From: Amber Willard
Sent: 15 July 2020 14:05
To: Zoe Toppin
Subject: FW: AL/23?20/HH Proposed Alterations and amendments to the Proposed Rear Dormer

Please upload as correspondence for AL/23/20/HH

project	26 Belle Meade Close, Woodgate, PO20 3YD
detail	Proposed floor plans, elevations and perspectives
drawn	JJH checked MSC
date	JUNE 2020 status
a1 scale	a3 scale
as shown	8901 02 rev A

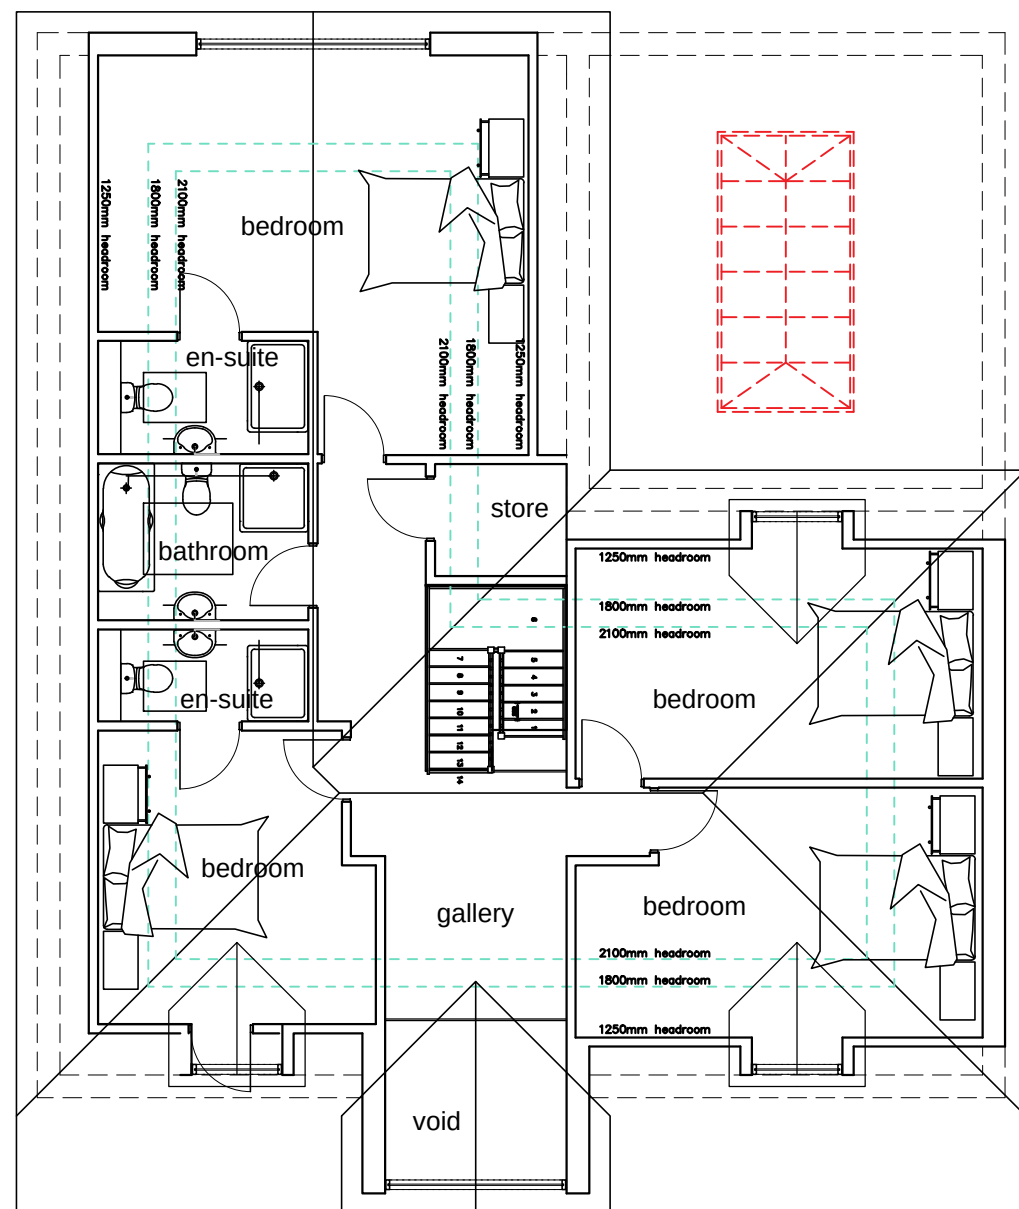
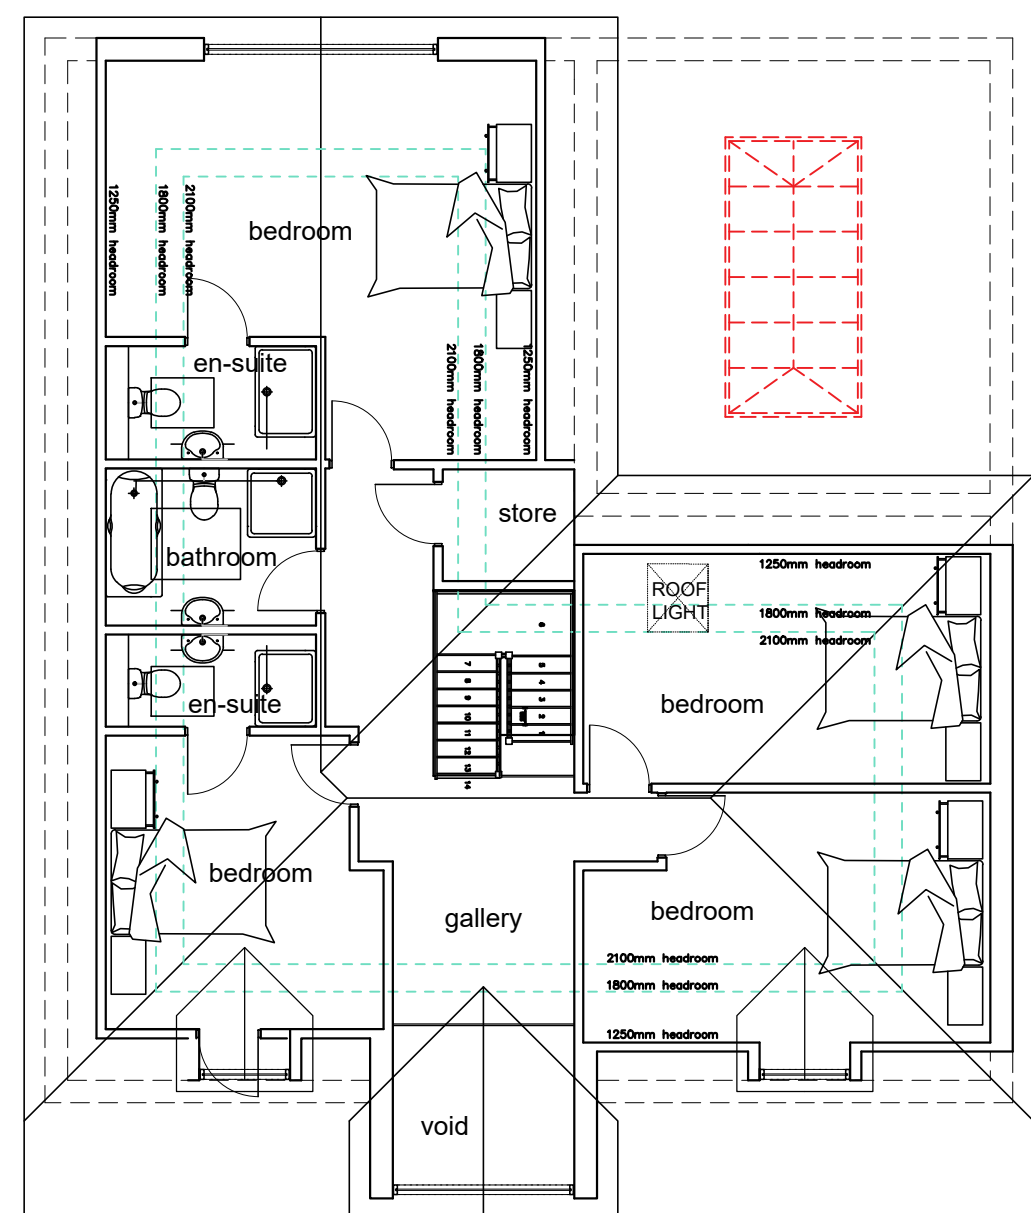
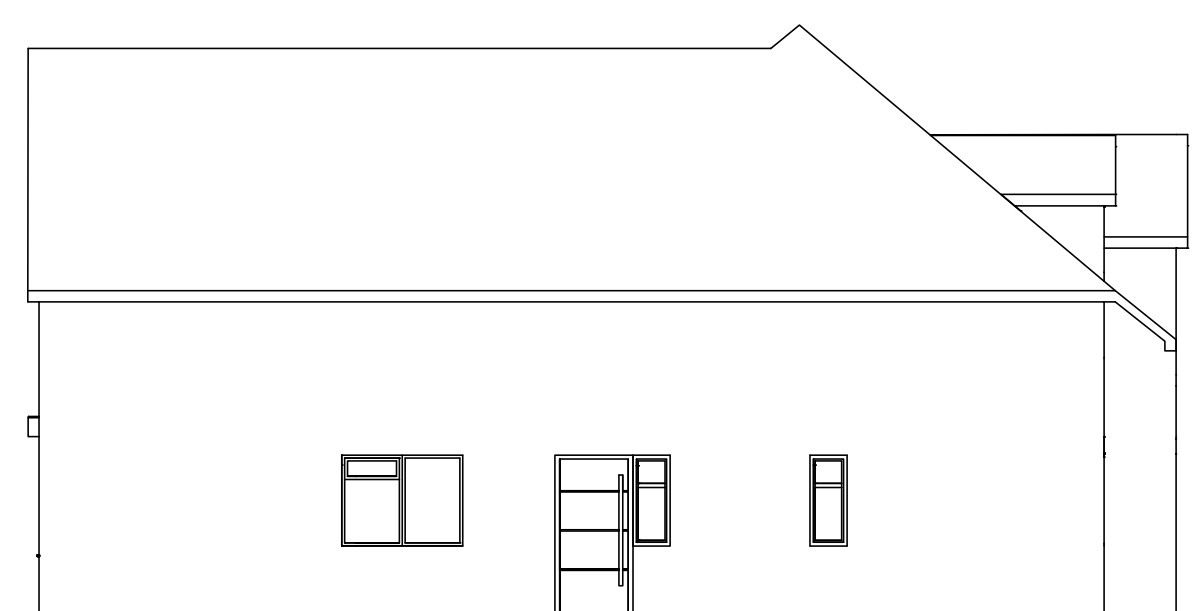
Mark has asked me to look into the concerns raised by the 'potential for overlooking from the bedroom facing to the rear above the single storey element'. And asked us to propose an alternate solution to overcome this issue.

Overall the alterations to this proposal now seek to have a Velux style skylight in place of the originally proposed dormer, this has been shown in the revisions undertaken to drawing 8901-02A. we feel that this should minimize and significantly reduce any concern raised about overlooking.
